REQUEST

Current Zoning: MX-3 (Mixed-Use, conditional)
Proposed Zoning: N2-A(CD) (Neighborhood 2-A, conditional)

Approximately 27.82 acres located east of Old Statesville Road, south of West W.T. Harris Boulevard, and west of Old Potters Road.

SUMMARY OF PETITION

SCHEMATIC SITE PLAN

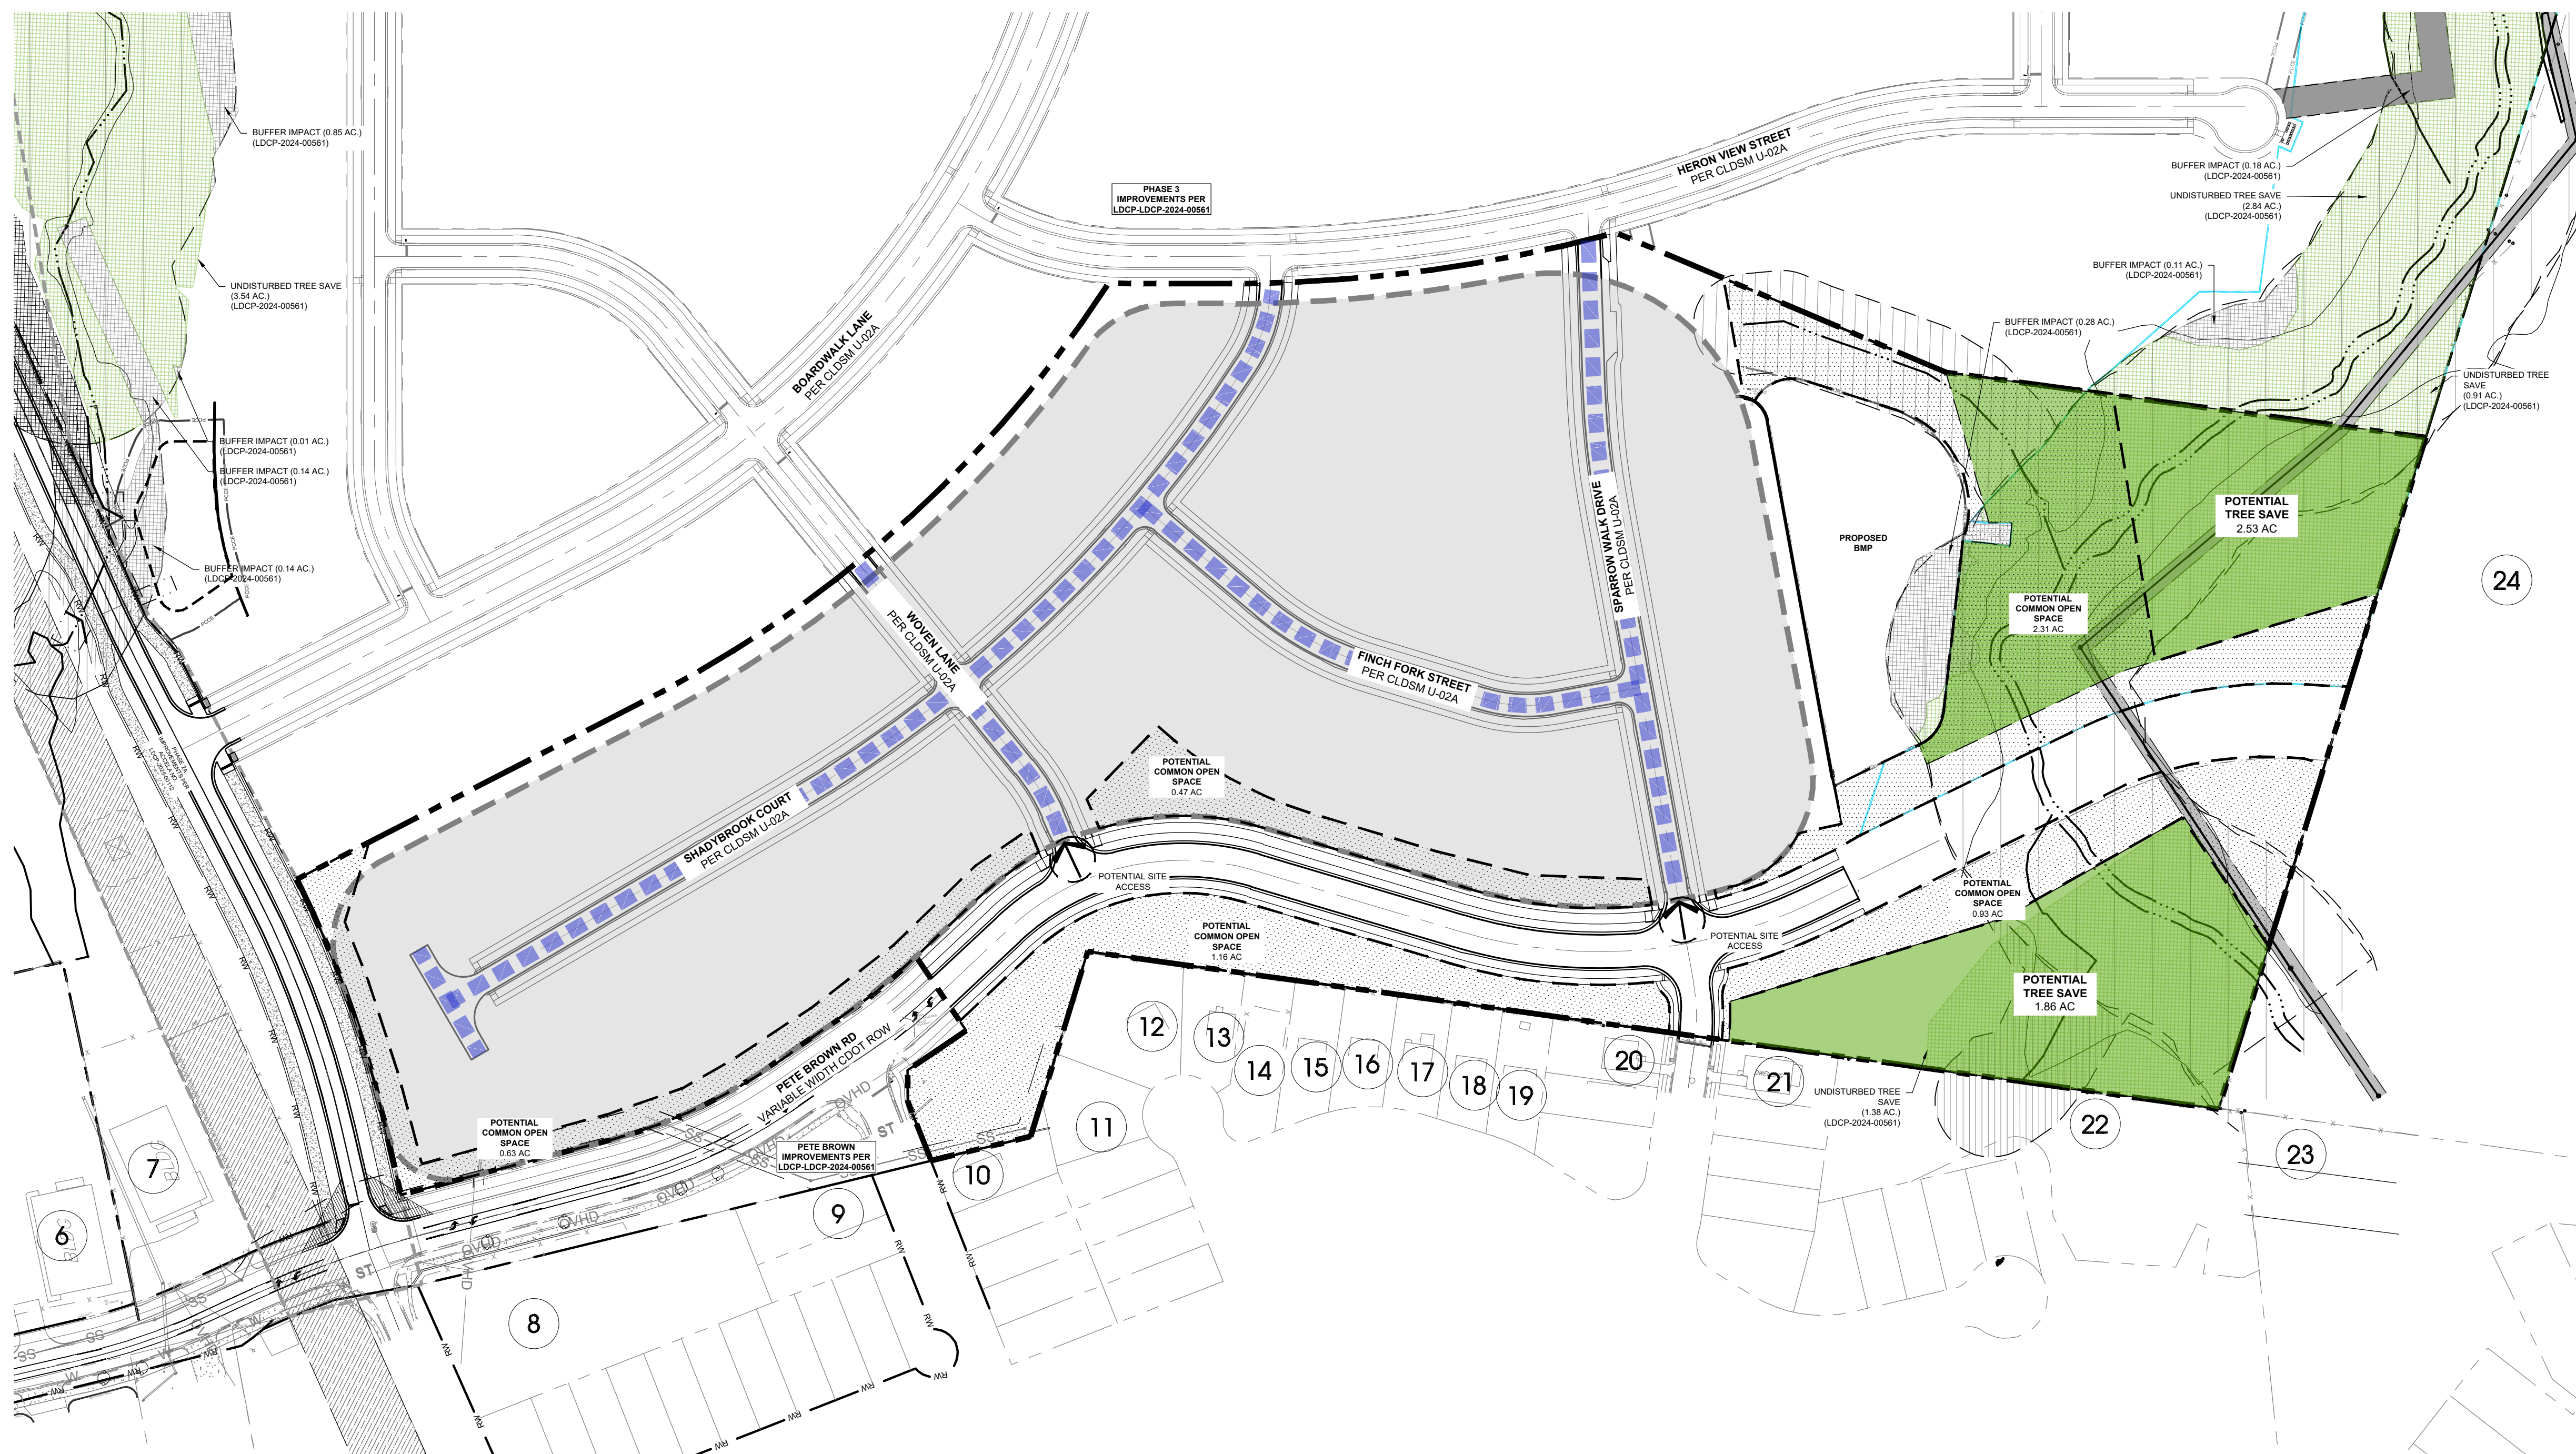
1. CDOT: Revise site plan and conditional notes to construct 8' sidewalks along all internal roads per UDO and CLDSM U-02B. Revise site plan and conditional note(s) to reflect this requirement.

2. Park and Recreation: label the greenway easement shown outlined in blue within the rezoning boundary.
